Your Ref: OWPC4906
Our Ref: AW/25/15/A 28-01-2015
Please ask for:
Mr S Davis

3 No. externally illuminated fascia signs, 2 No. non illuminated fascia signs & 2 No. non illuminated panel signs to various elevations (resubmission following AW/215/14/A).

The Ship Inn Aldwick Street Aldwick

DRAWING
PROPOSED SIGNAGE SITE PLAN
PROJECT
**THE SHIP INN
ALDWICK STREET
BOGNOR REGIS PO21 3AP**

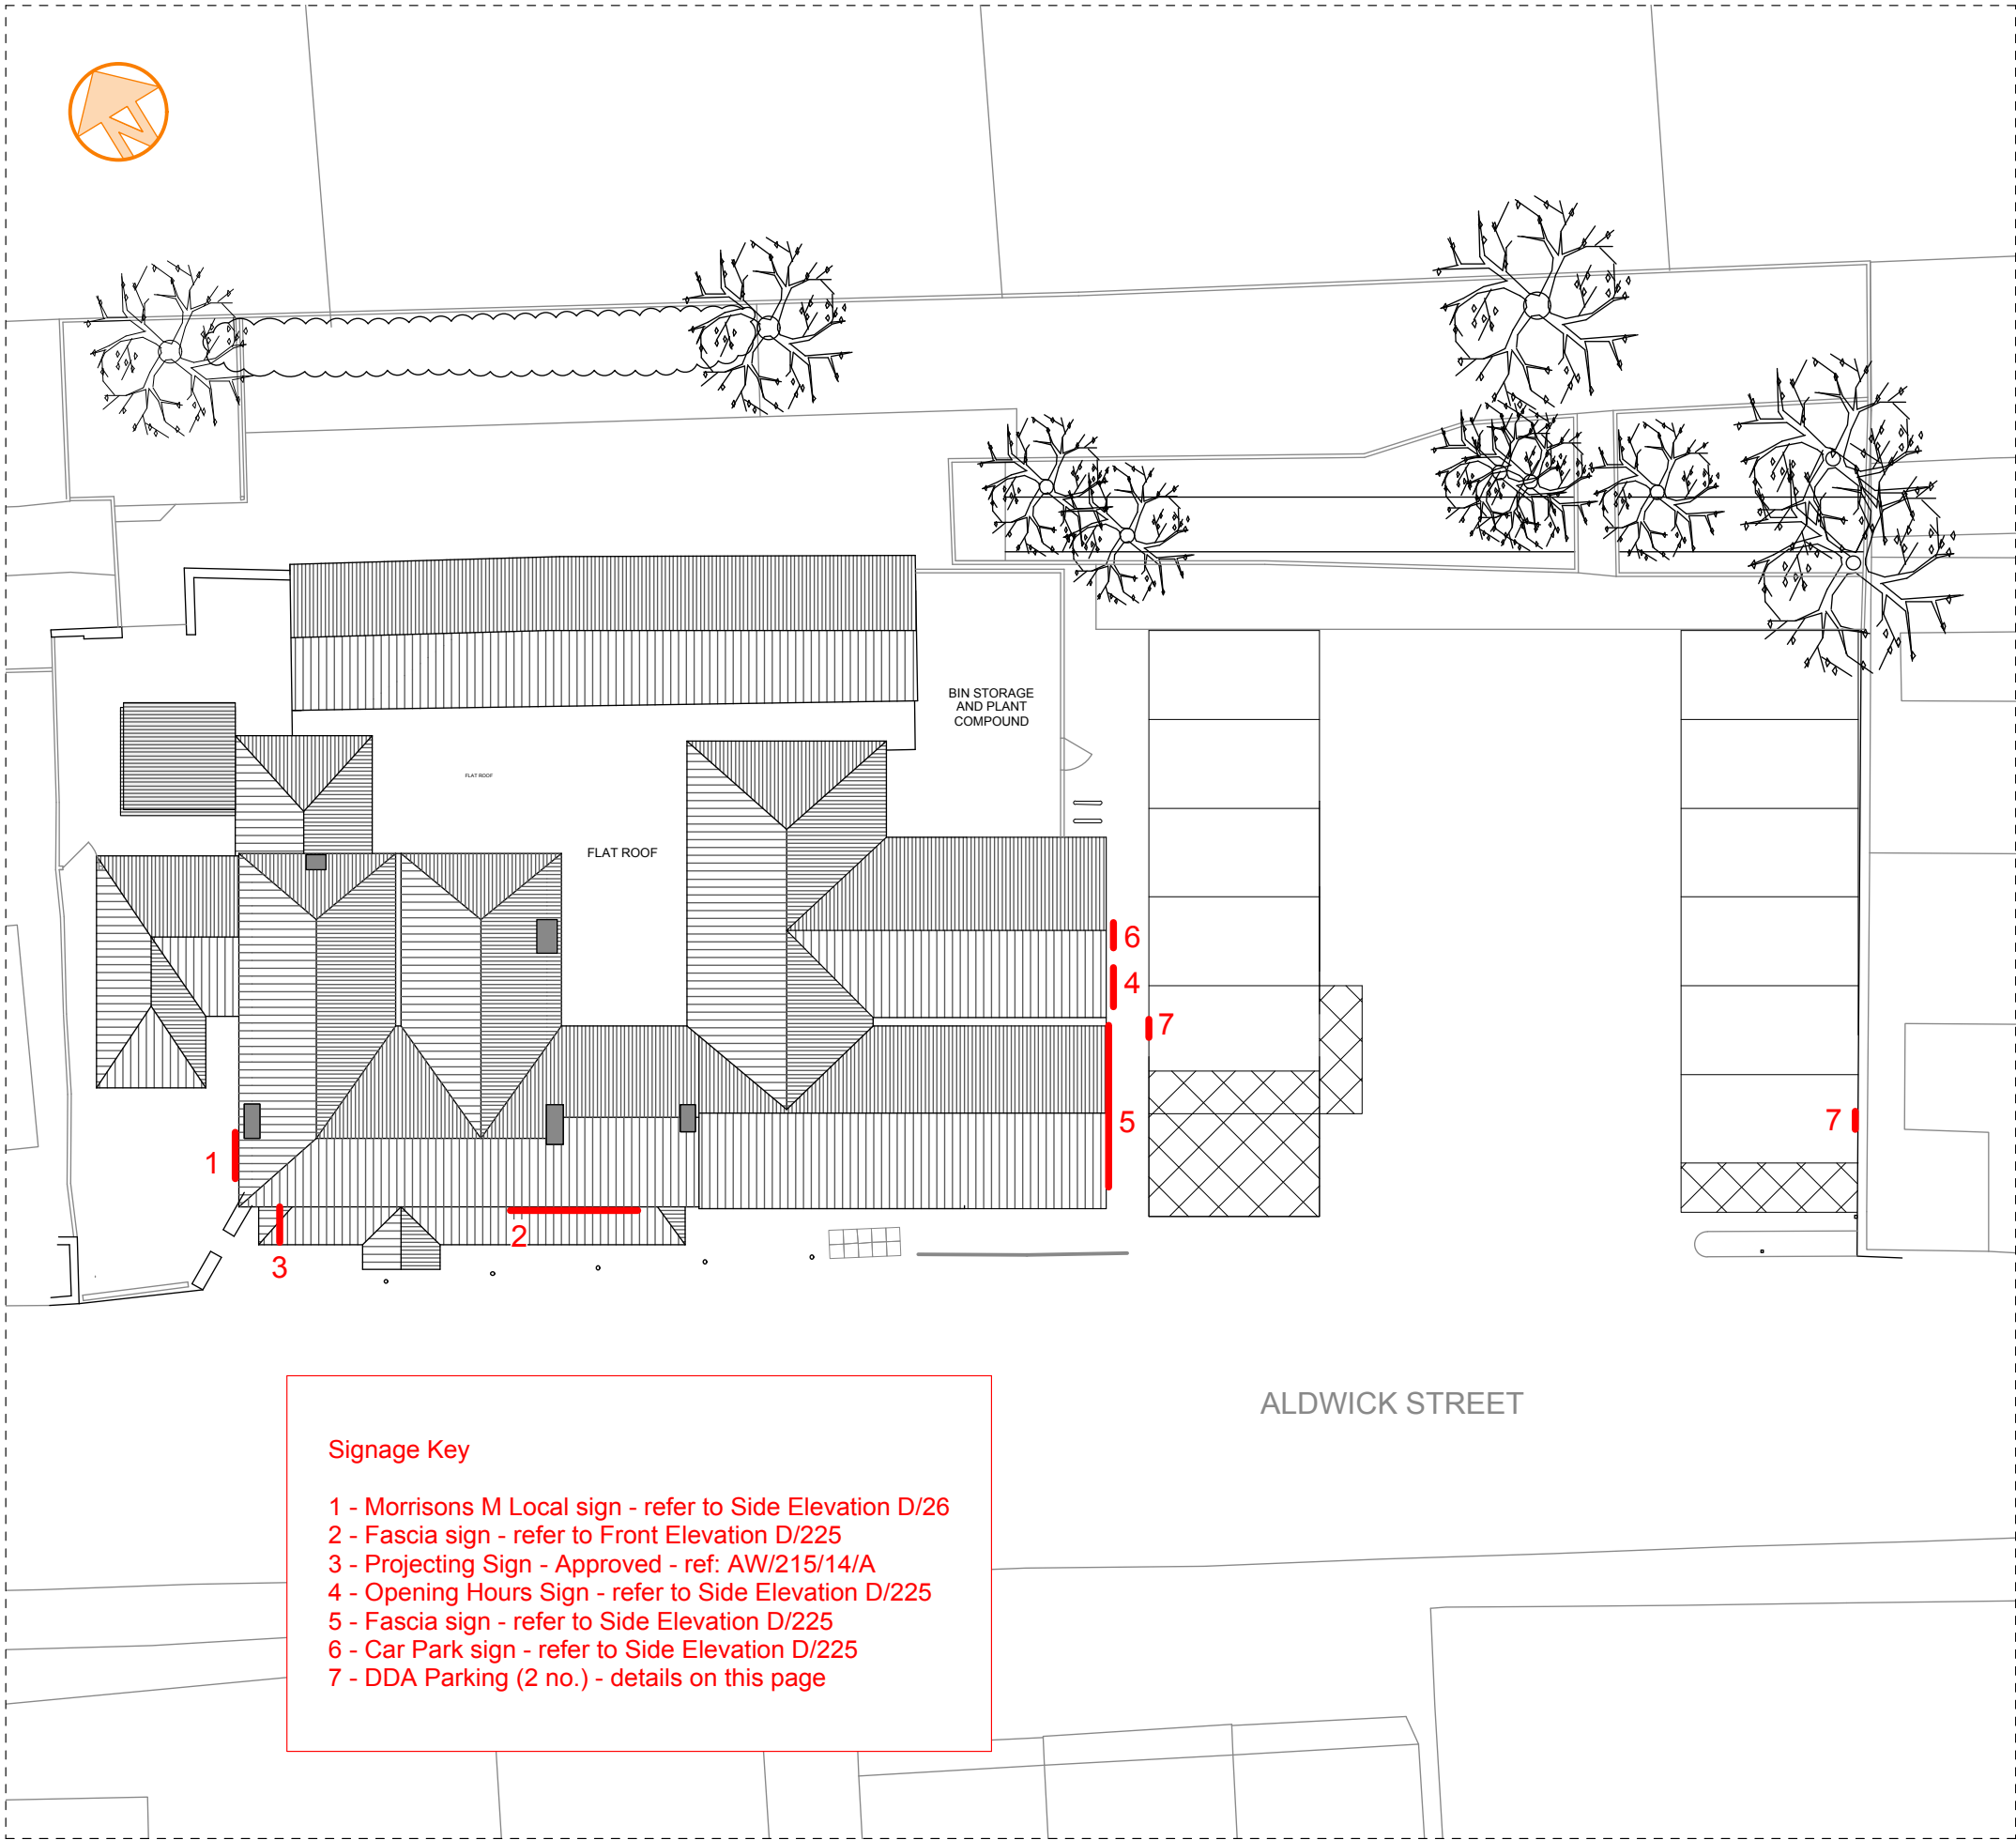
Signs 1 and 7 as shown on the plan are OK. Sign 2 is far too large and also unnecessary, since anyone standing opposite the building will already be aware the it is a Morrison's store, and don't need reminding of this travesty. Sign 3 should remain as 'The Ship Inn'; Sign 4 is far too large, and could be a discreet A4-sized sign on the door. Sign 5 is again far too large. Sign 6 is simply a waste of time, since it is obvious that it is the car park for the store.

The size of the proposed signs 2, 4 and 5 is far larger than necessary, and the illumination of signs 2 and 5 in particular will cause a nuisance to nearby properties.

I would urge the Council to reject all except signs 1 and 7, to insist that sign 3 remains as it is, and that all illumination of signs is extinguished between the hours of closing and the hours of reopening.
